From: Ross Leal
Sent: 19 December 2017 08:09
To: Planning.Responses
Subject: FW: FG/183/17/PL - Land adj to The Barn, Hangleton Lane, Ferring

I've been passed your comments dated 13/12/17 on the application. I note you have raised questions with regard to the vehicular access and pedestrian access. I have looked at this further and I have the following comments:

DRAWING TITLE
Proposed site plan,
Block plan and Location Plan

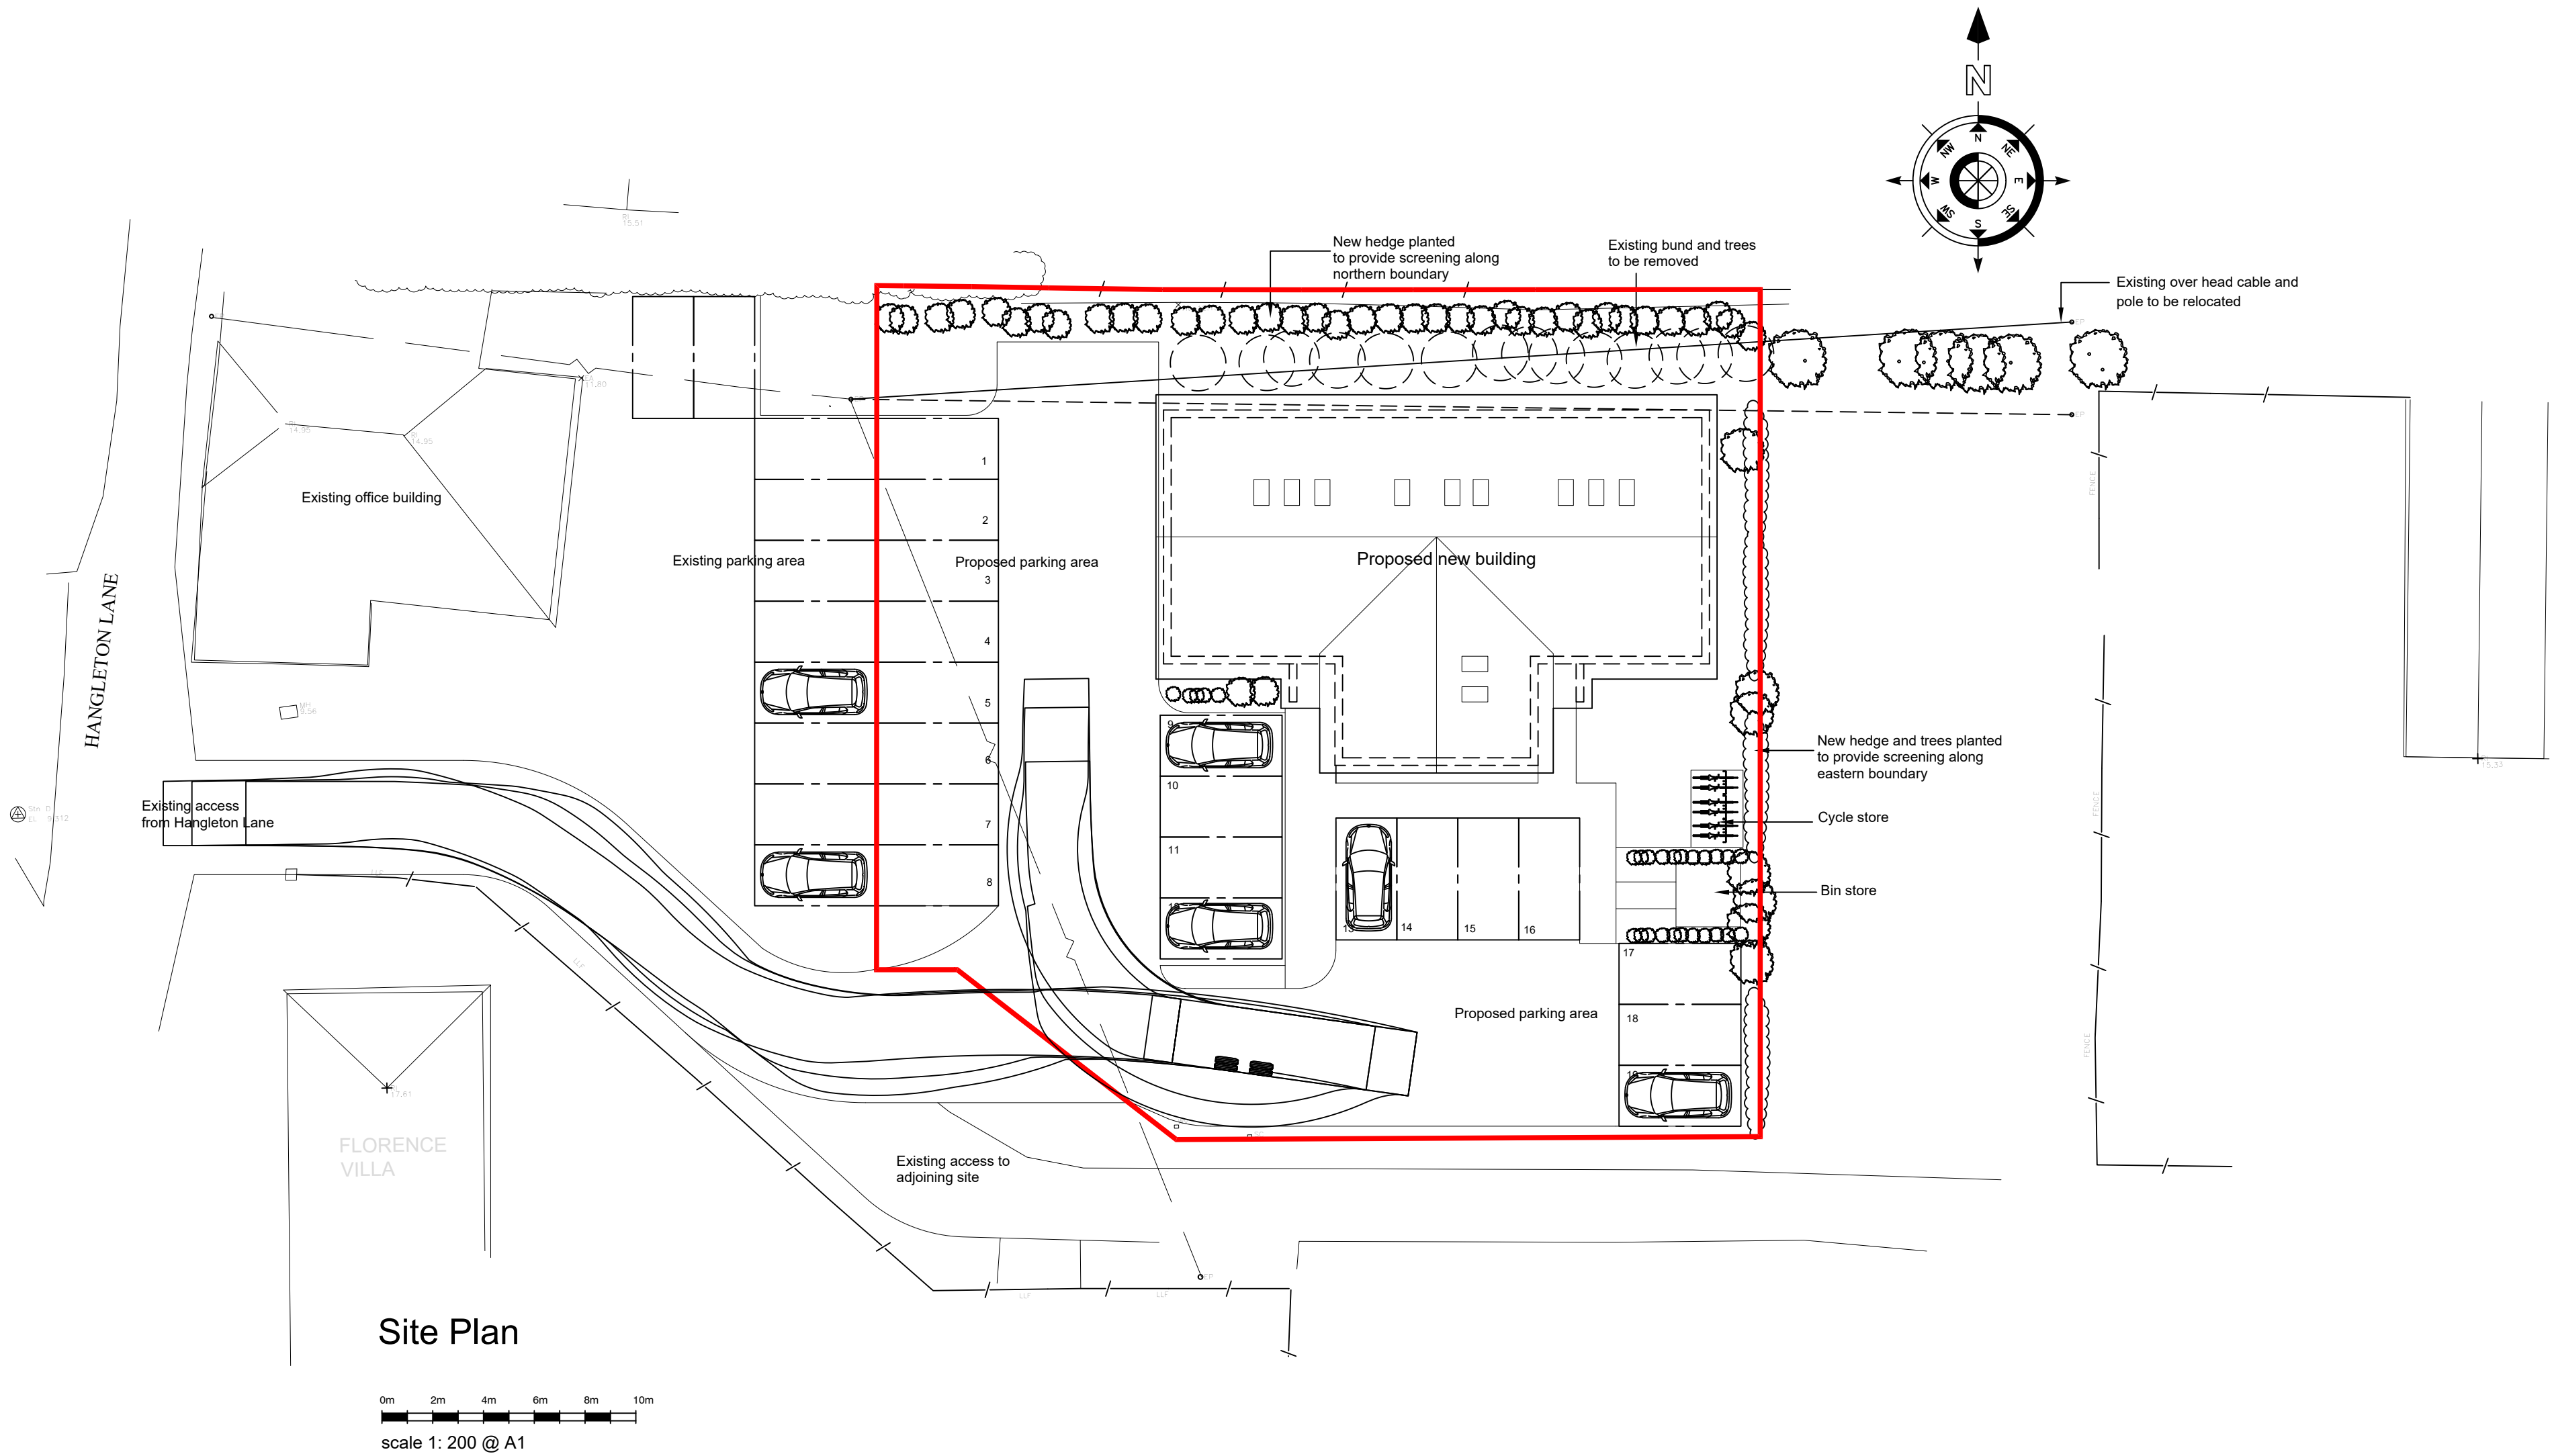
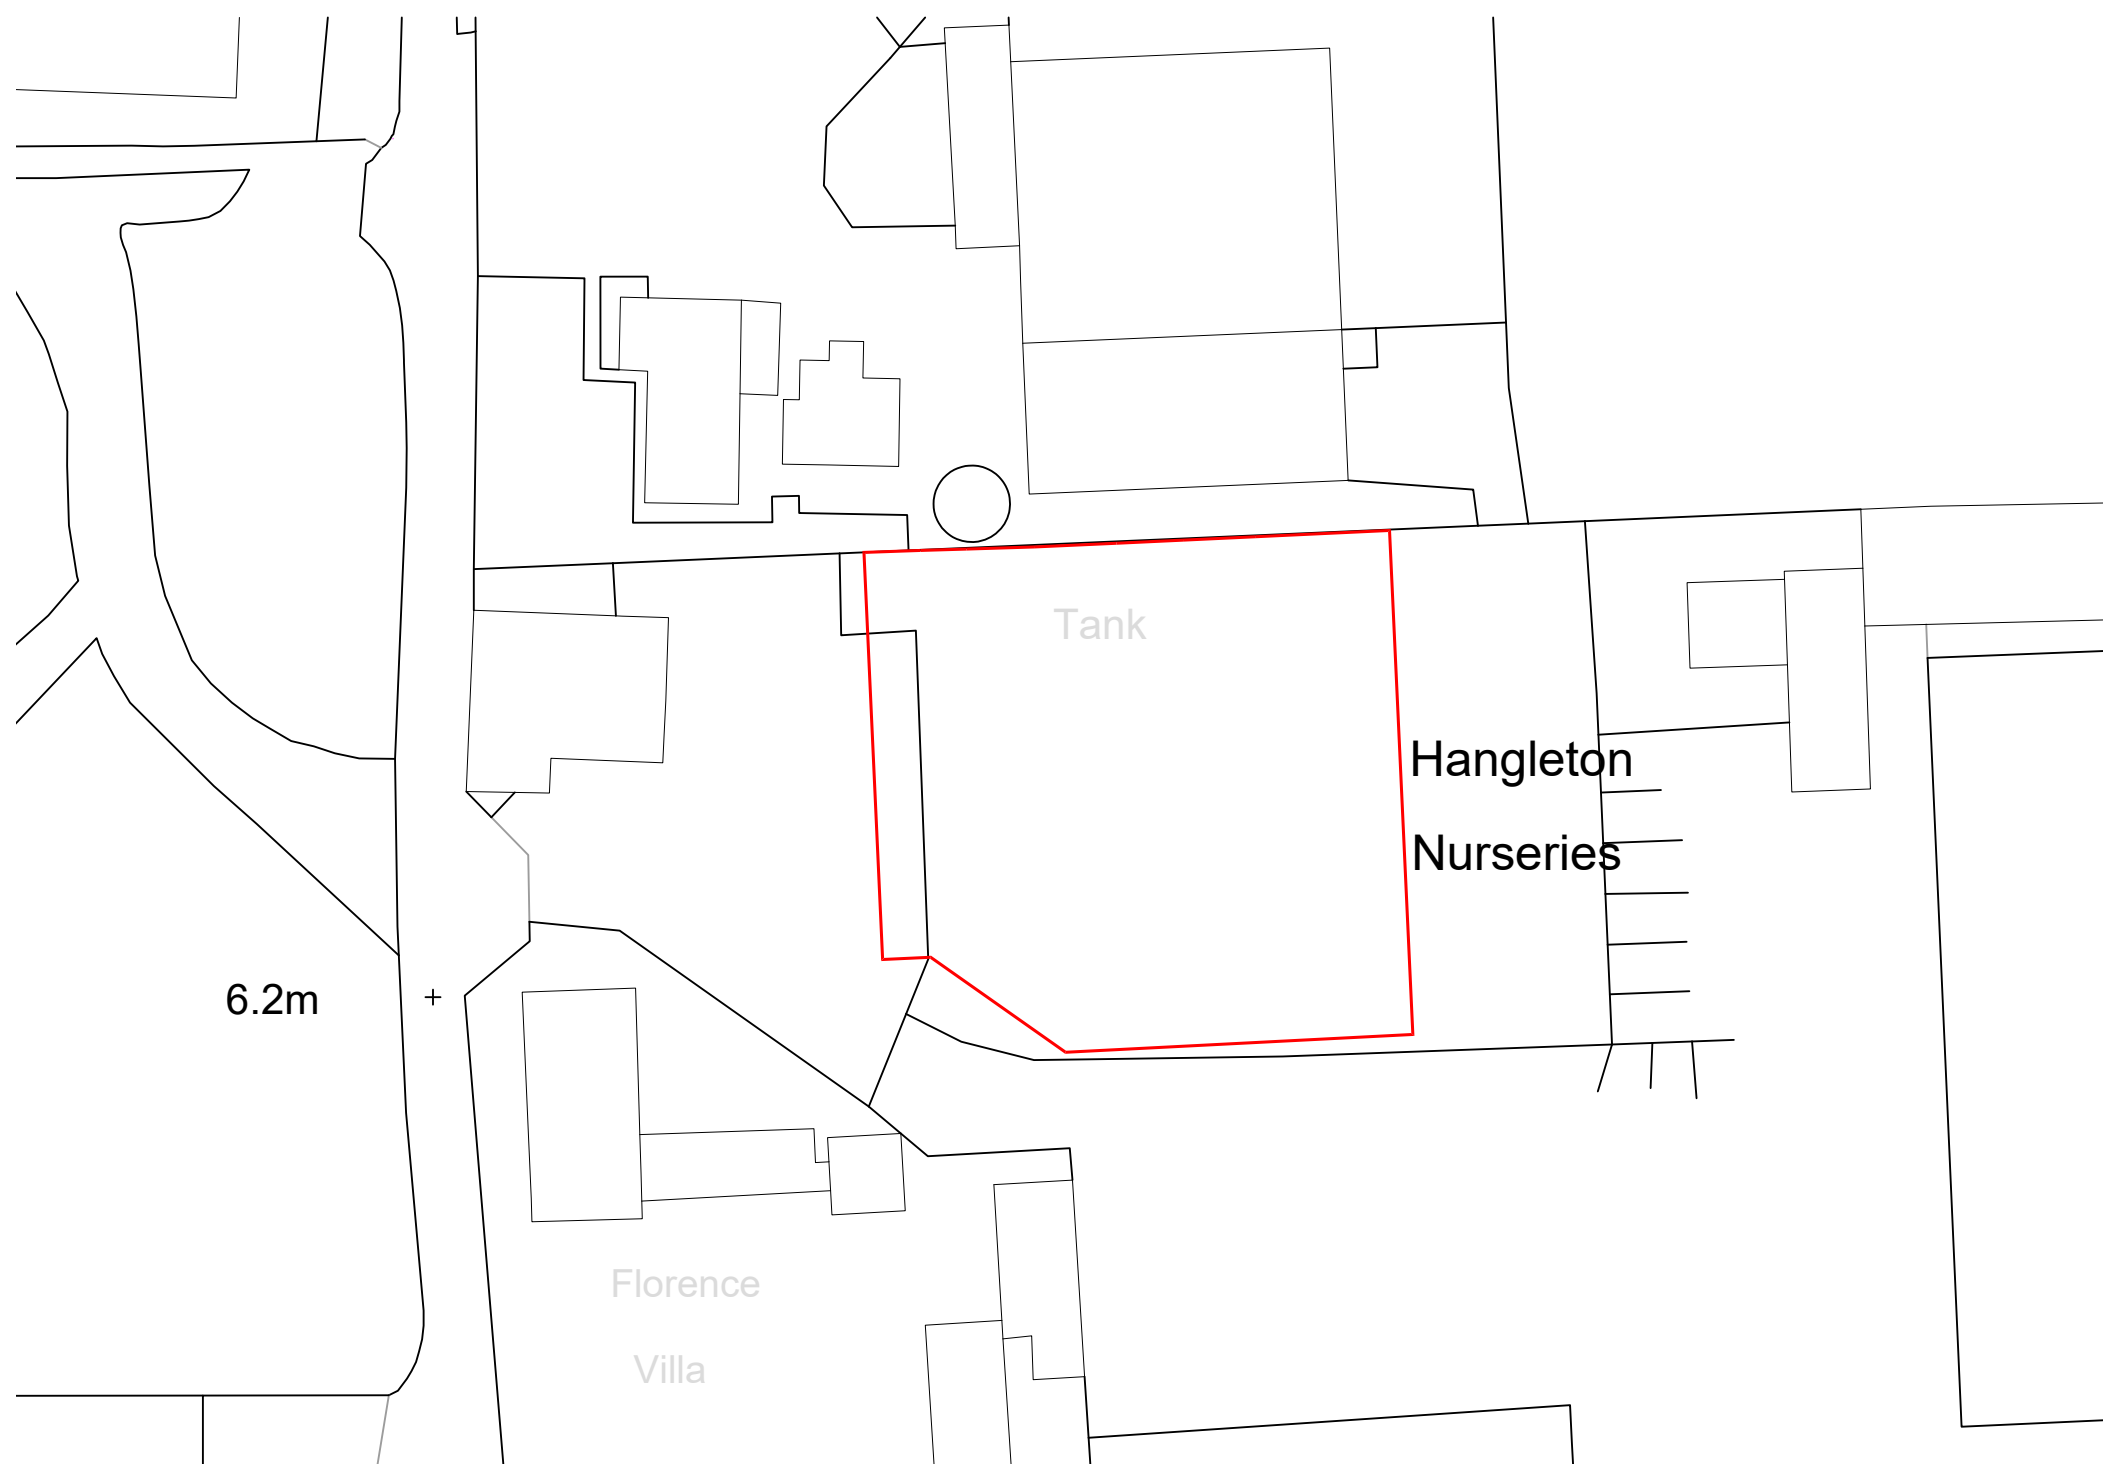
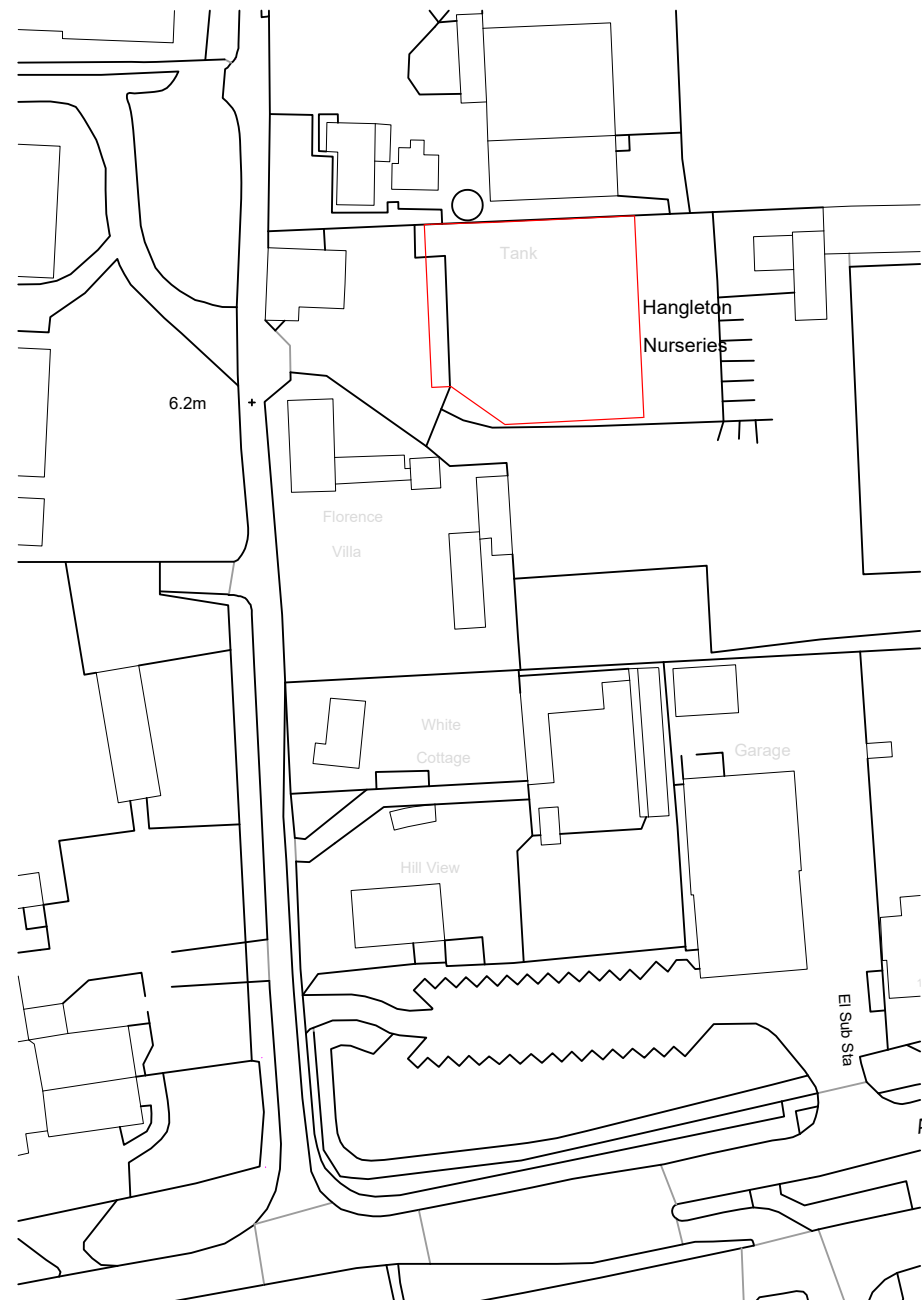
The existing access is shown in the attached Google extract. It is around 7m wide although may have been partially overgrown. The site was previously used for vehicle storage and it is likely that it would have been used by larger vehicles delivering cars. The proposed use is generally going to be car trips with deliveries and refuse collection, so once a week at most. Therefore, the existing access would seem adequate.

As you have highlighted, there is no footway along the majority of Hangleton Lane and little prospect of delivering one due to land ownership issues! There is of course, a short section of footway on the east side of Hangleton Lane close to the A259 junction. In addition, on the A259, there is a wide footway/cycleway which leads to a TOUCAN crossing to the east. There is then a cycleway/footway running along the A259 to the east and west. Therefore, there are good local facilities within a short distance of the site. You specifically asked for the numbers, so we have looked at the TRICS Database. This suggests that as a maximum, there would be one additional pedestrian trip in each peak with up to 15 in a day, although I believe the actual numbers will be less in this location. I would therefore, suggest

that bearing in mind the slow nature of vehicle speeds and the relatively low flows, then pedestrian can walk in the lane for the short section up to the site.
